03 December 2021

Re: SSD-17424905 – 20 Avon Road, Pymble

We write to formally submit an objection to the proposed development on the following grounds:

|   | The significance of the visual impact of the proposed scheme at this location is judged to be <b>high/moderate</b> .   |

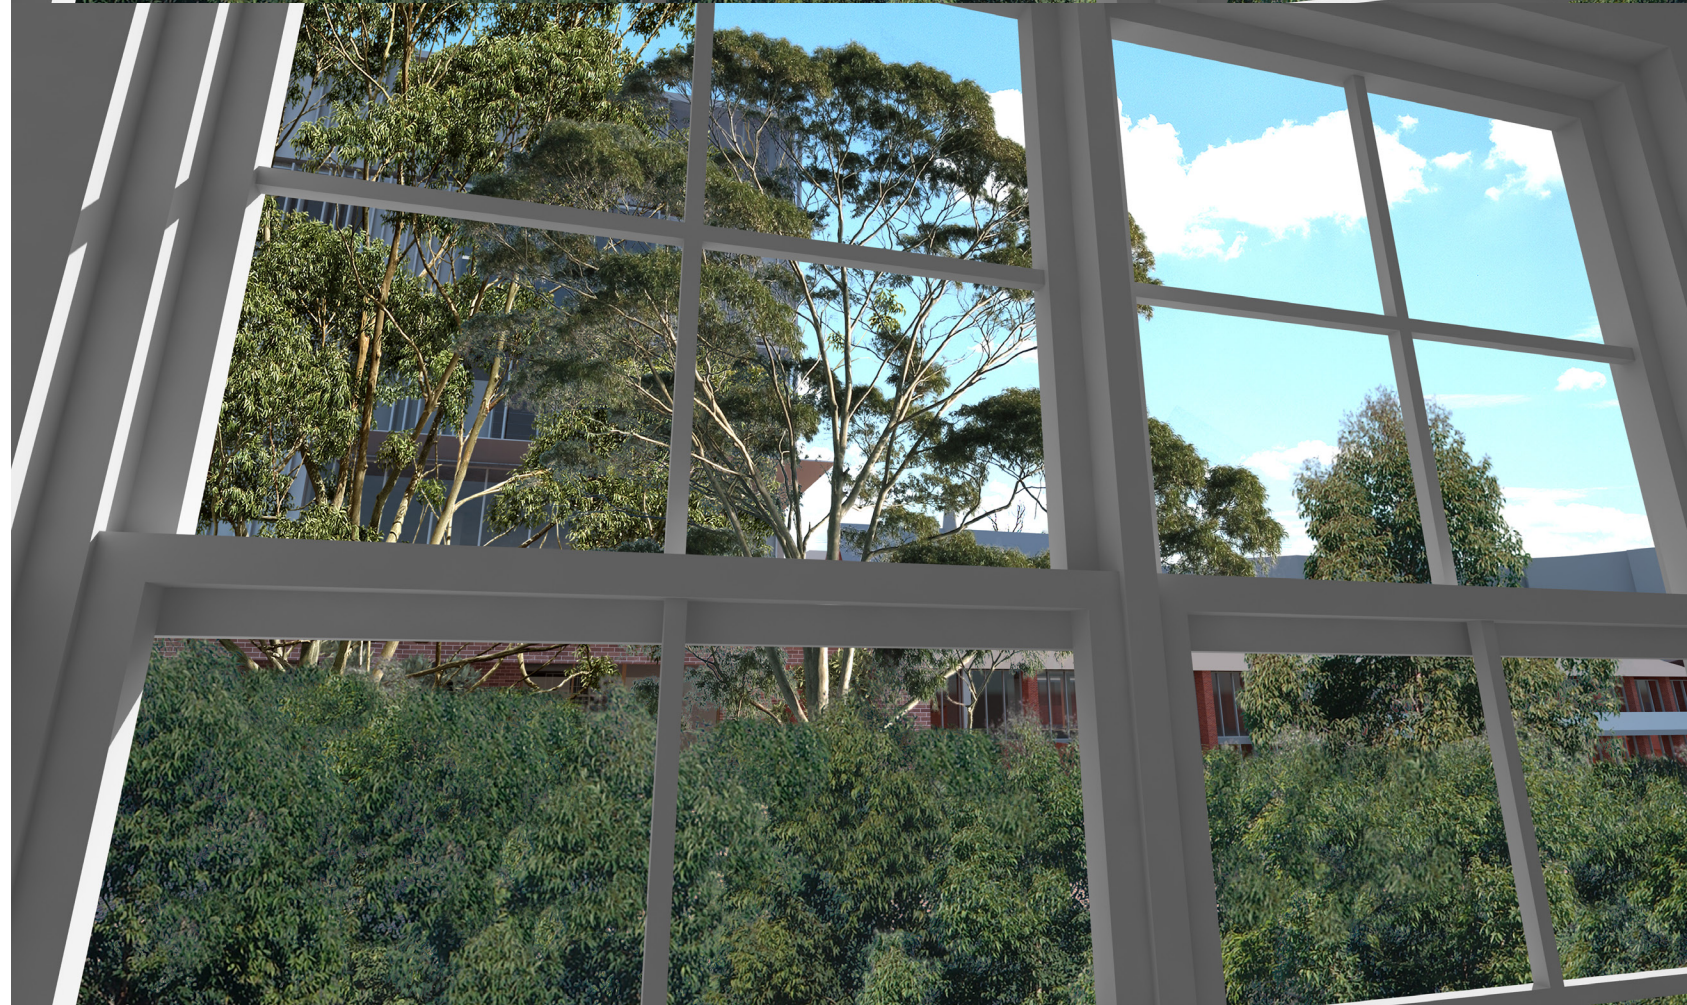
Figure 4: Extract of photomontages from Visual Impact Assessment (Source: Geoscapes)

The images highlight that the replacement vegetation after 10 years will only screen the lowest floor and levels 2, 3 and 4 will continue to be visually obtrusive and highly visible.

ISSUE
AR-DA-C10-AA-01
8

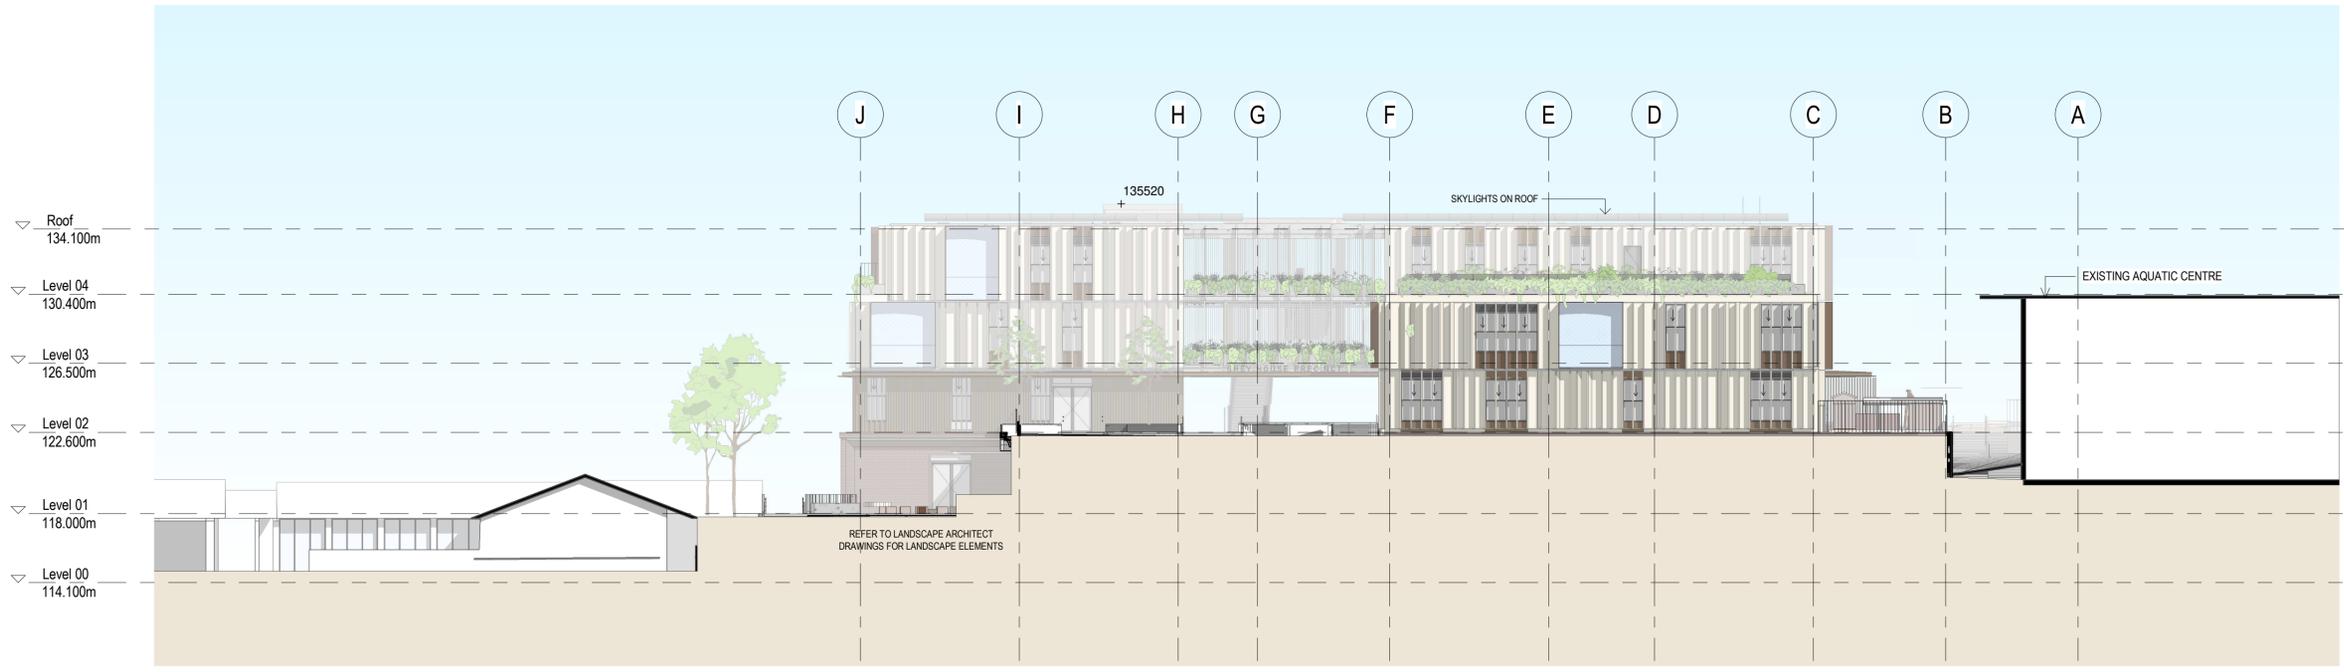
The proposed five storey (5) Grey House building is of a bulk, scale and design that is unsympathetic to the low-density residential environment to the south east. The proposed building should be amended to be of a lesser height, more recessive in design, bulk and scale and provide a transition in scale to the two (2) storey dwellings directly to the south.

Figure 2: Extract of architectural drawings showing southern elevation (Dwg. No. DA-C10-AA-01) of the proposed development (Source: BVN Architecture)

Whilst we note that no maximum building height applies to the site, the proposed 20m+ building dwarfs the surrounding single and two (2) storey residential dwellings directly to the southeast, significantly impacting on the visual privacy and visual amenity of No. 59B Pymble Avenue due to the five (5) storey scale and 62m length of the proposed southern elevation.

AR-DA-C10-AA-02 | 9

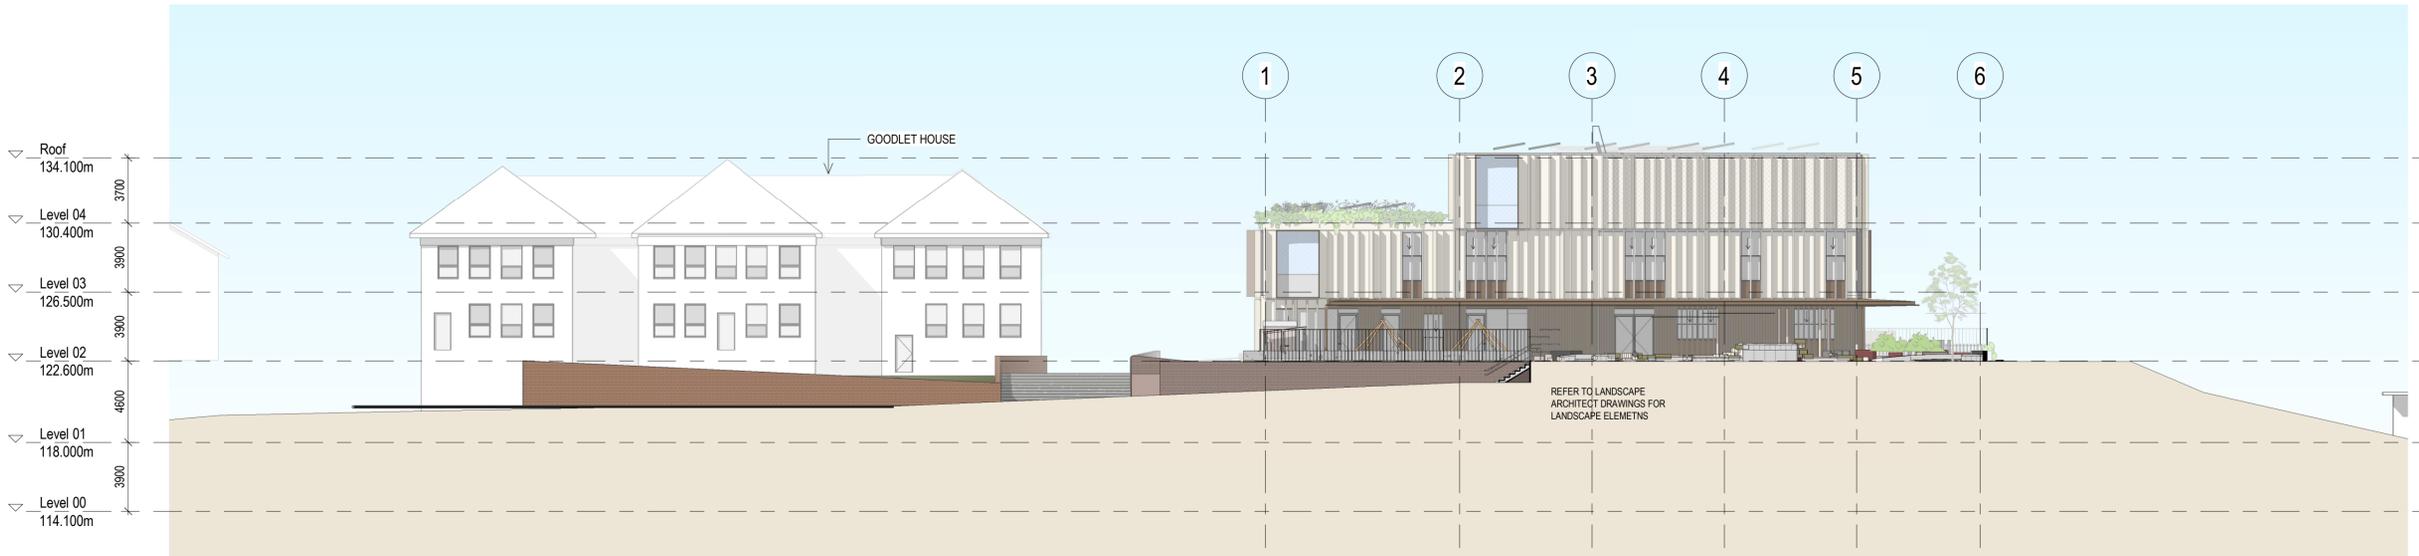
Figure 1: Extract of architectural drawings showing eastern elevation (Dwg No. DA-C10-AA-02) of the proposed development (Source: BVN Architecture)
